From: Abiel X. Carrillo
Sent: Wednesday, March 09, 2016 2:32 PM
To: 'Michelle Madrid'
Cc: 'georgen@smithengineering.pro'
Subject: Central KOA Conceptual Grading and Drainage Plan - K22D056

Based upon the information provided in your submittal received 1-20-16, the above referenced Grading Plan is approved conceptually, and appears to comply in general, with the City's Drainage Ordinance. Please be aware that this is not an approval to move forward with grading or construction.

Project Title: Central Albuquerque KOA Kampground Building Permit #: _____ City Drainage #: K220056

DRAINAGE PLAN

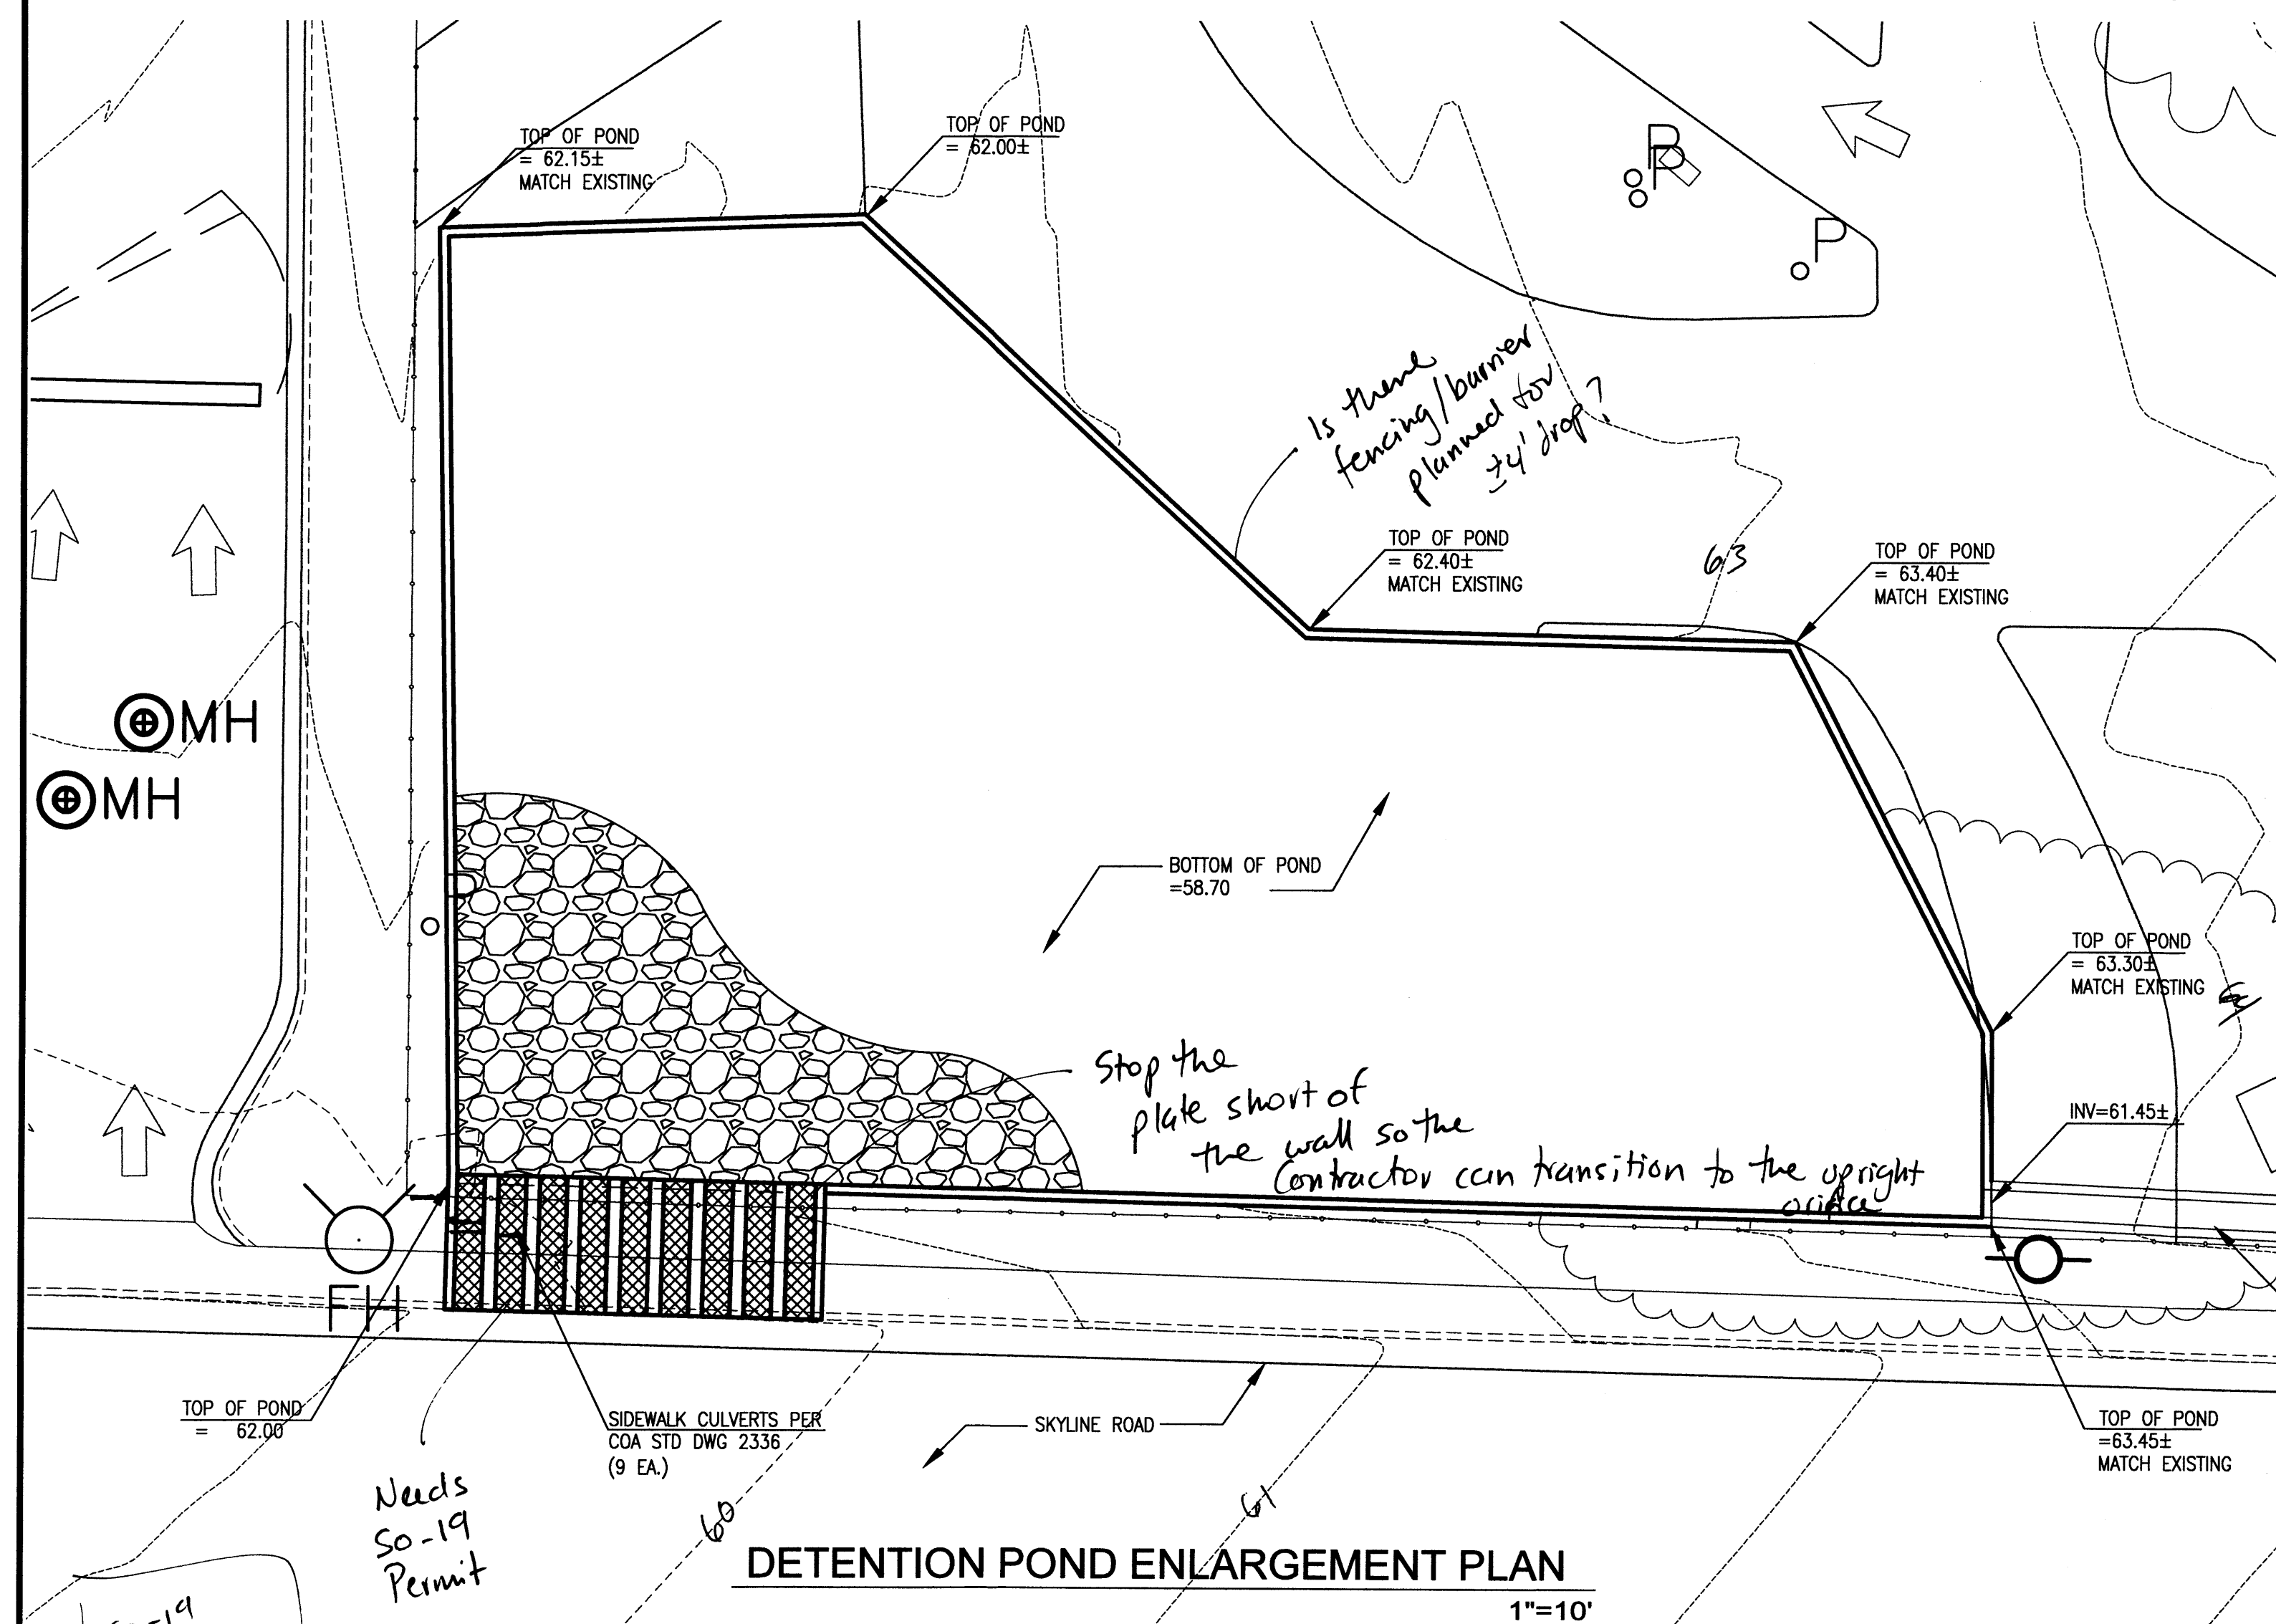
2. The work proposed within City Right of Way will require a SO-19 Permit (Private Drainage facilities in the Right of Way), and the inspection and acceptance of the facility. Please add the Standard SO-19 notes (attached) to the plan.

3. It appears that the top of the wall is to be set at the existing ground. Is there any barrier/fence to separate vehicles and/or pedestrians from the vertical drop?

SHEET NO:
2A

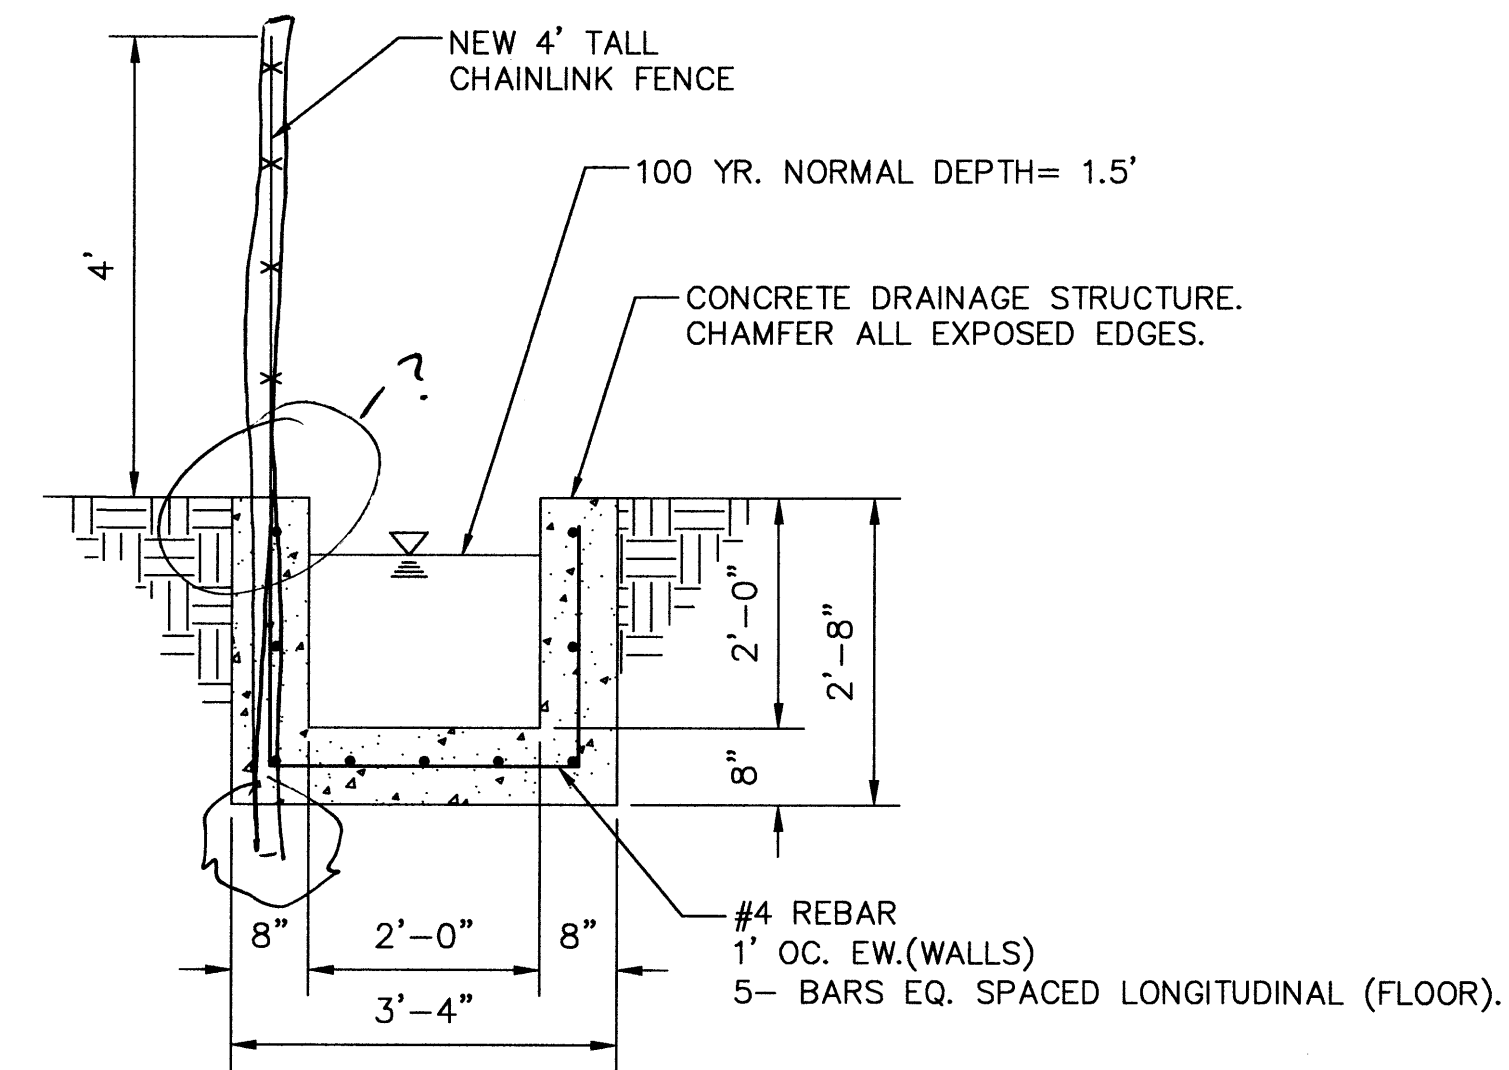
1. The sidewalk culvert array will need to be installed flush with the sidewalk and following the sidewalk slope without any grade breaks. The channel would be then be slightly rotated, relative to the wall opening. I recommend extending the metal plate of the culvert no more than 2 feet behind the sidewalk (no less than 18"), so that the Contractor can transition and tie to the wall opening properly. This will also allow the City to clean the culvert without needing to access the other side of the wall.

TYPICAL DRAINAGE CHANNEL

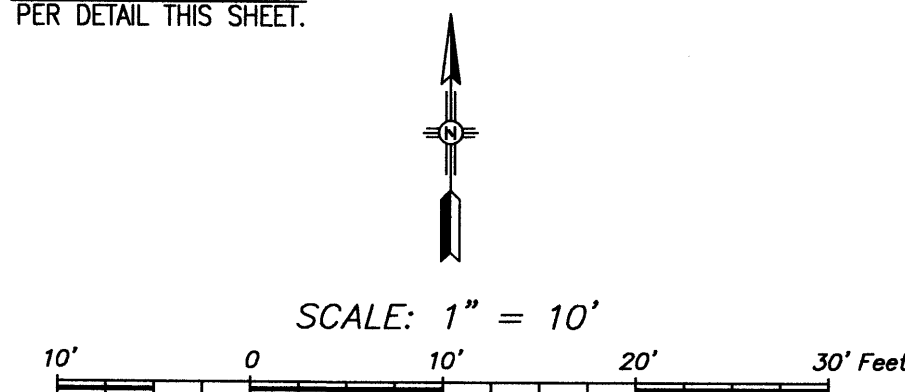
4. The typical drainage channel shows a fence aligned with the sidewall of the channel, we recommend (not require) off-setting the channel from the fence to avoid the need to shape the wall around the fence posts.
